Addendum No. 2

RE: Contract # C203977 WBS # 53022.3.1 F. A. # NHPIM-0040(050) Johnston County (I-5781)

I-40 From SR-1010 (Cleveland Road) To West of SR-1211 (Morgan Road)

The following revisions have been made to the Roadway plans:

TIP NO.	SHEET NO.
I-5781	PMP-2
APPROVED: <i>Joseph B. Kopaskie</i>	
DATE: 10/6/2017

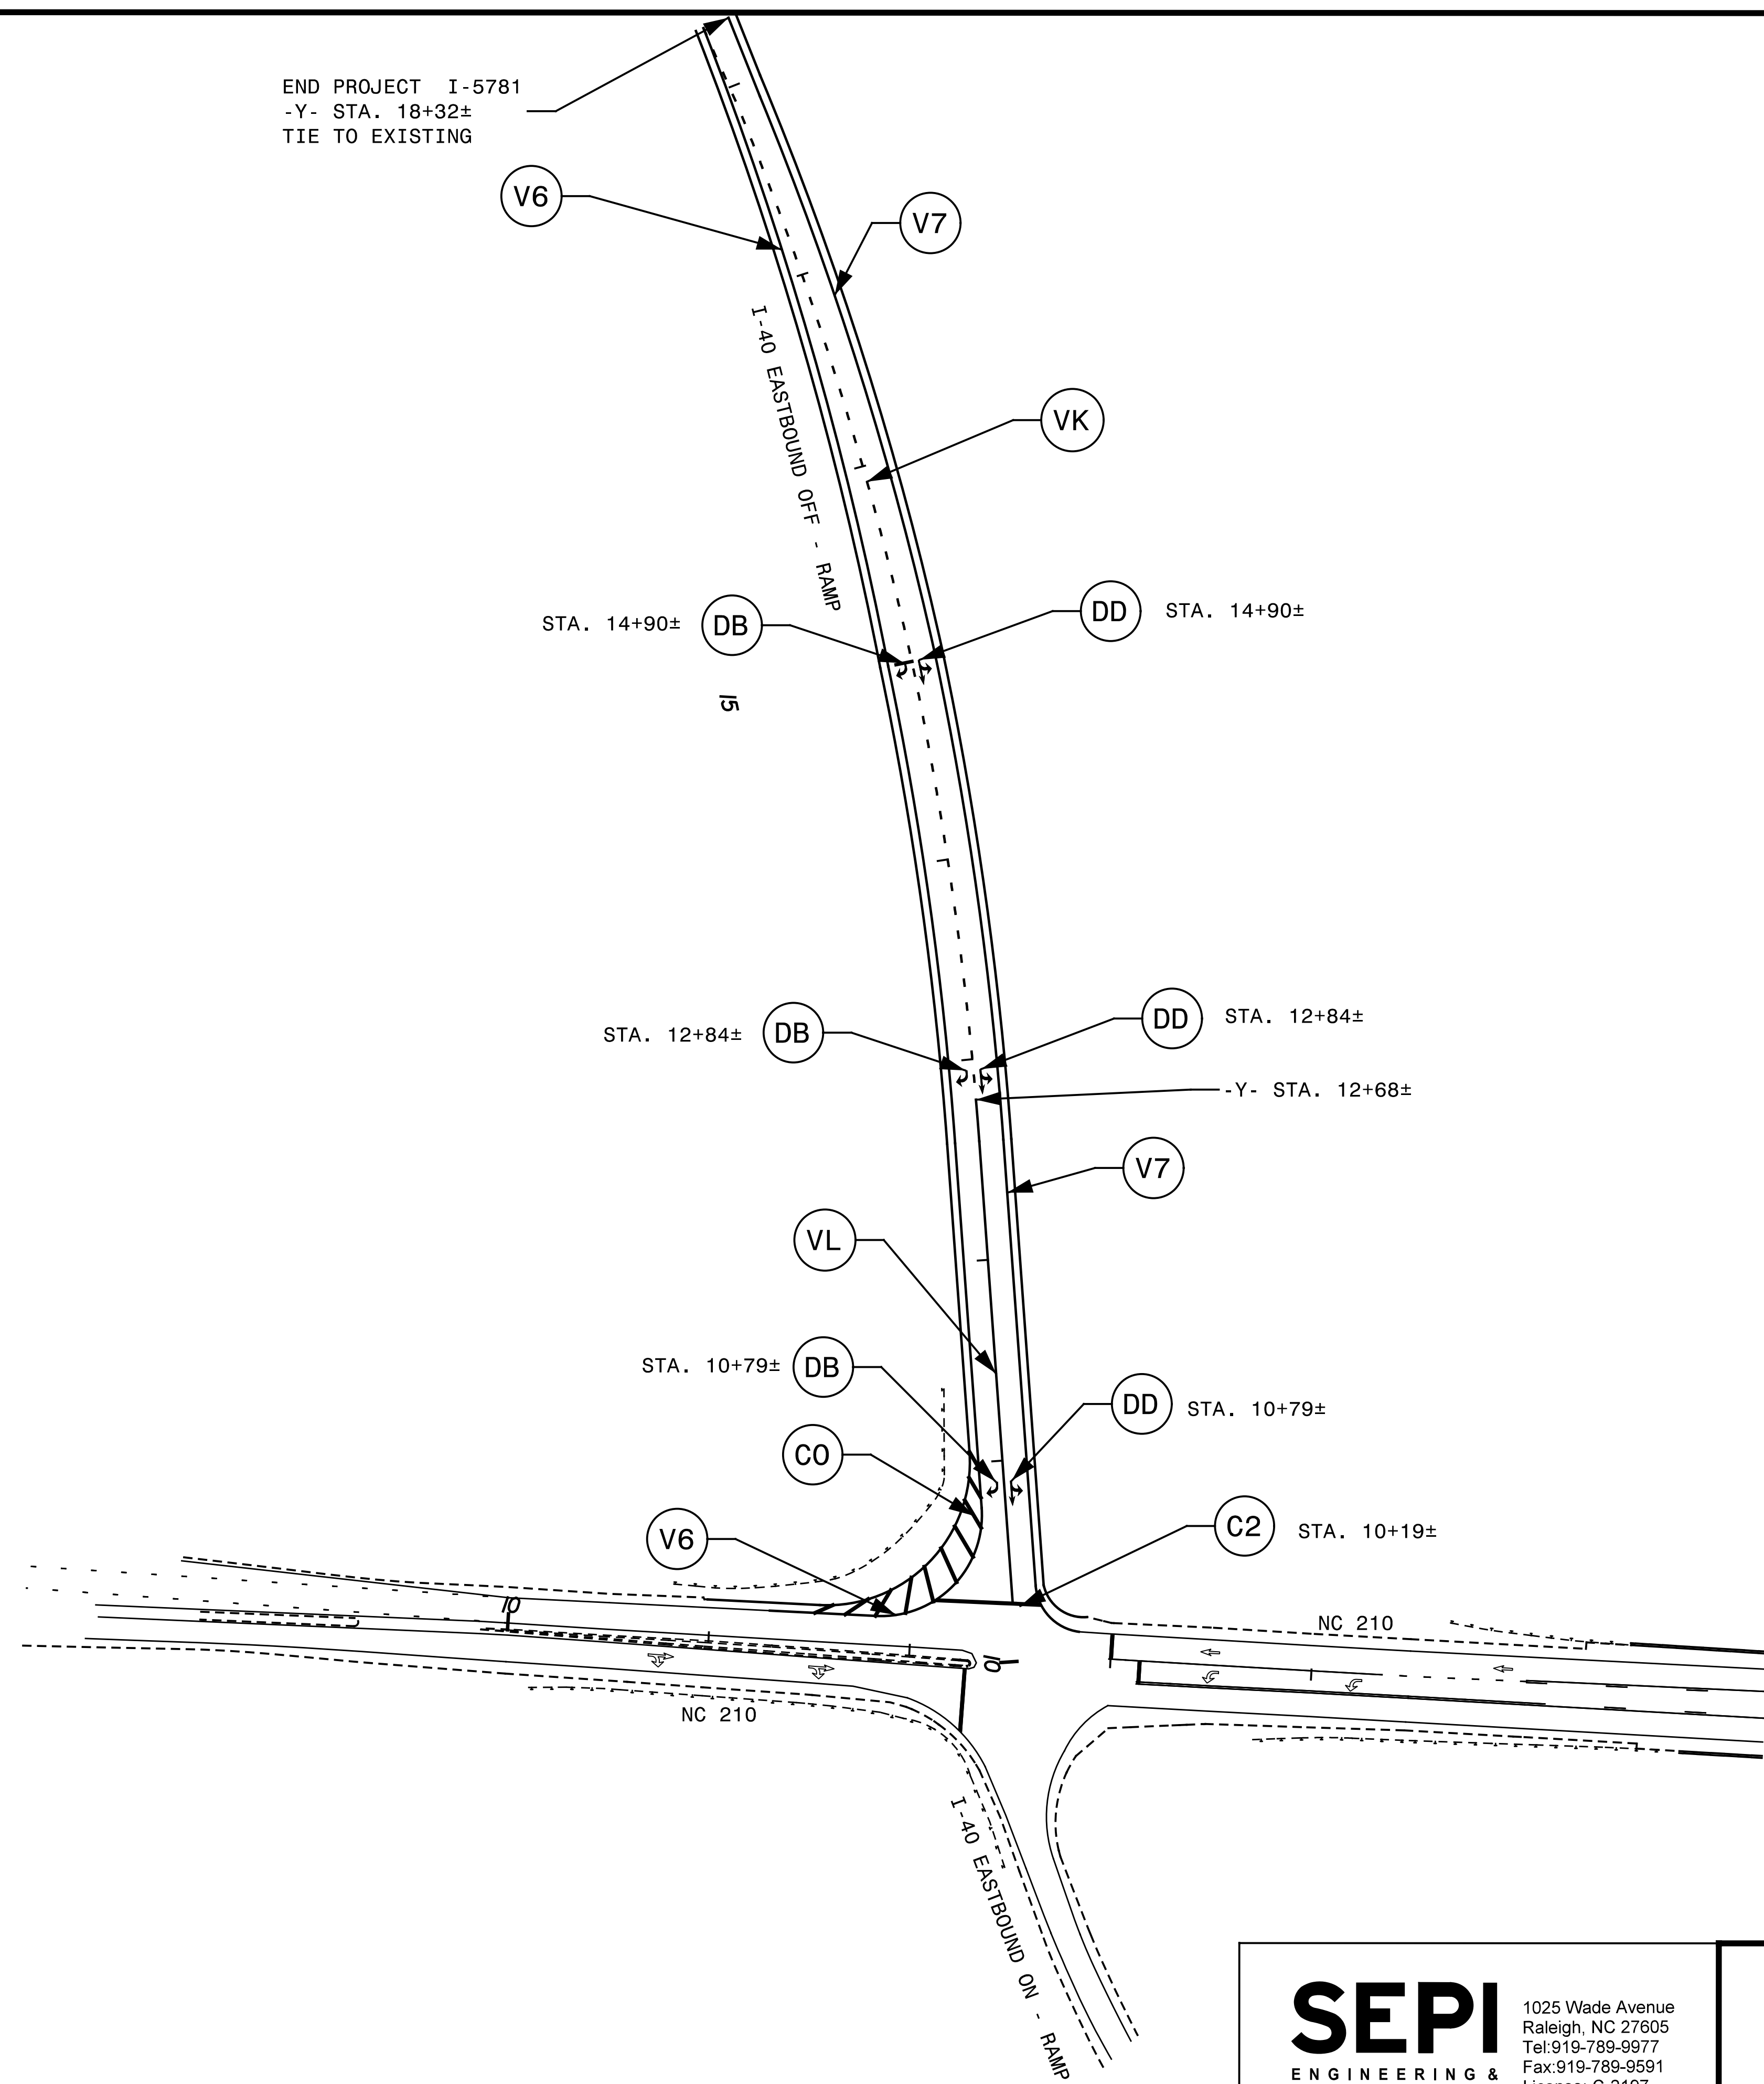
Sheet No.	Revisions
PMP-1 and PMP-2	Revised to reflect the change in pavement markings as noted in
(second revision)	Addendum #1
